From: Paul Cann
Sent: 21 February 2014 11:39
To: Planning.Responses
Cc: Simon Davis; Thomas Callaway
Subject: RE: Planning Consultation on: AL/95/13/

Engineers comments in respect to surface water drainage:

Site Address: Land west of Oaktrees Fontwell Avenue Aldingbourne PO20
 3RU

Description of Works: Outline planning application for 3 no. detached houses with
garaging - This is a Departure from the Development Plan

Drawing Name
Site Layout Plan

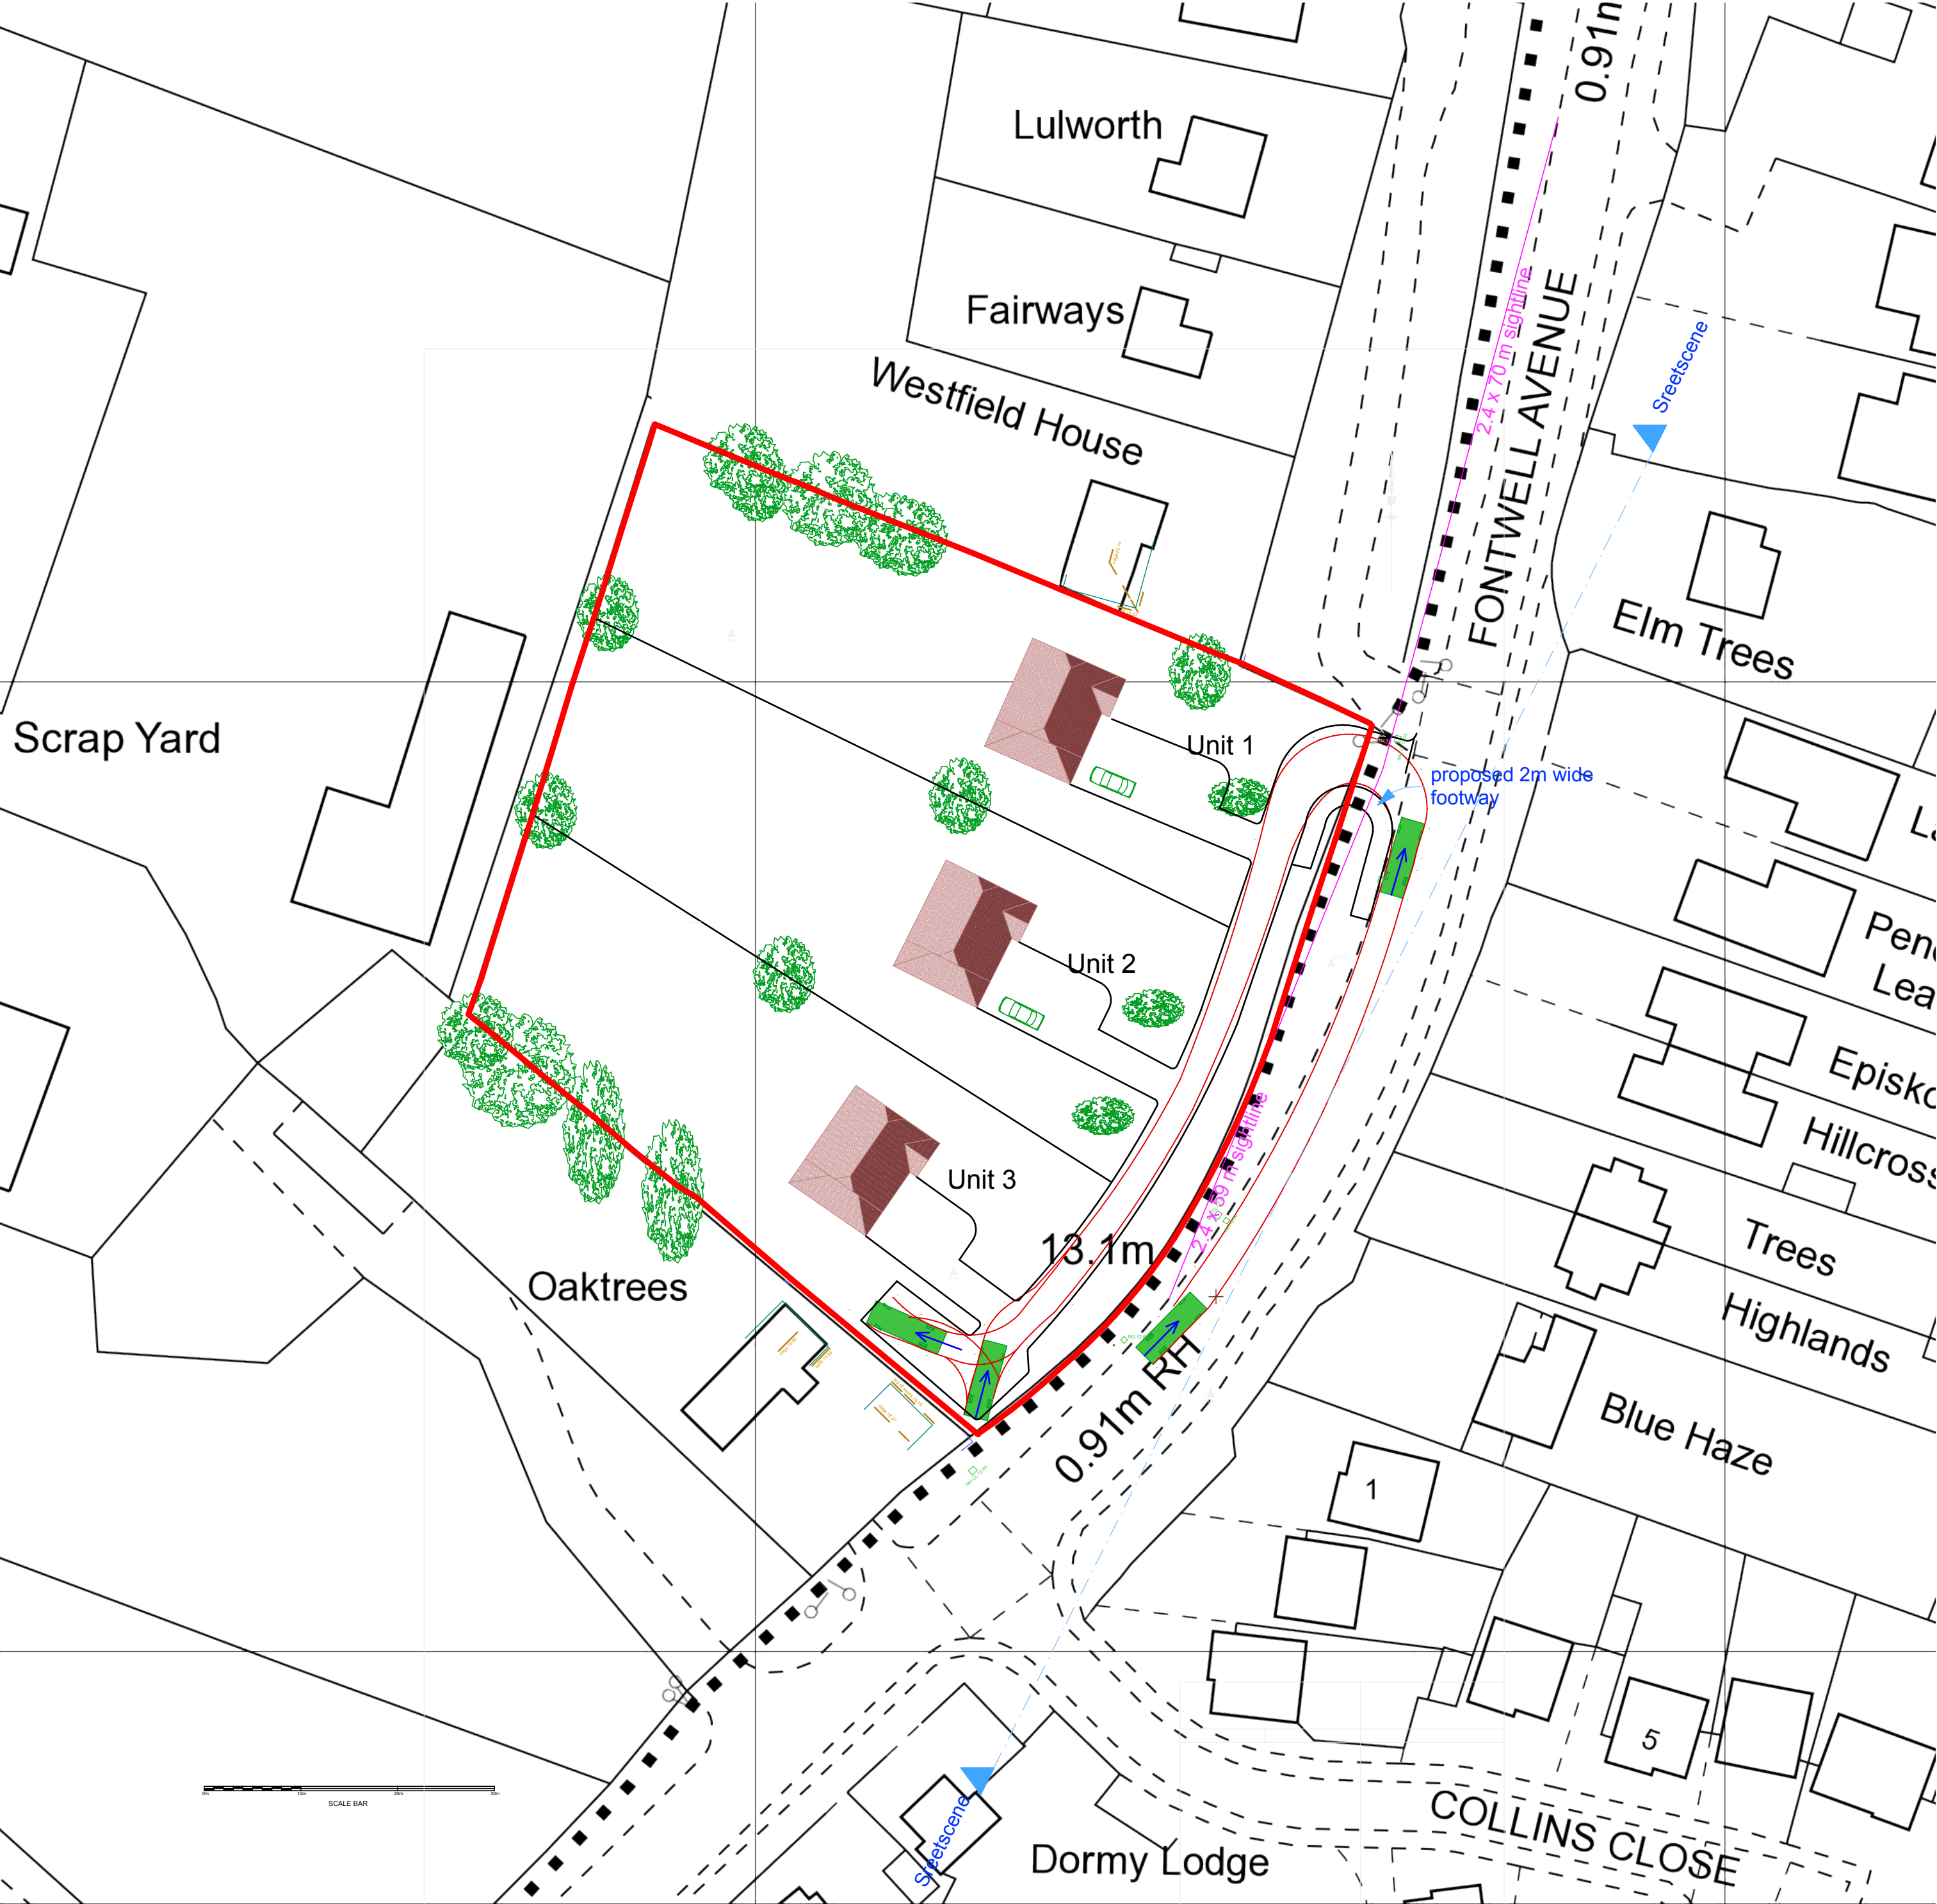
A SuDS system (Sustainable Urban Drainage System) must be investigated for surface water disposal, ie. soakage structures. Soakaways/SuDS have been specified on the application form but no detailed information has been provided in terms of a surface water disposal scheme.

It is noted that the site lies partly within flood zone 2 and therefore a flood risk assessment will be required.
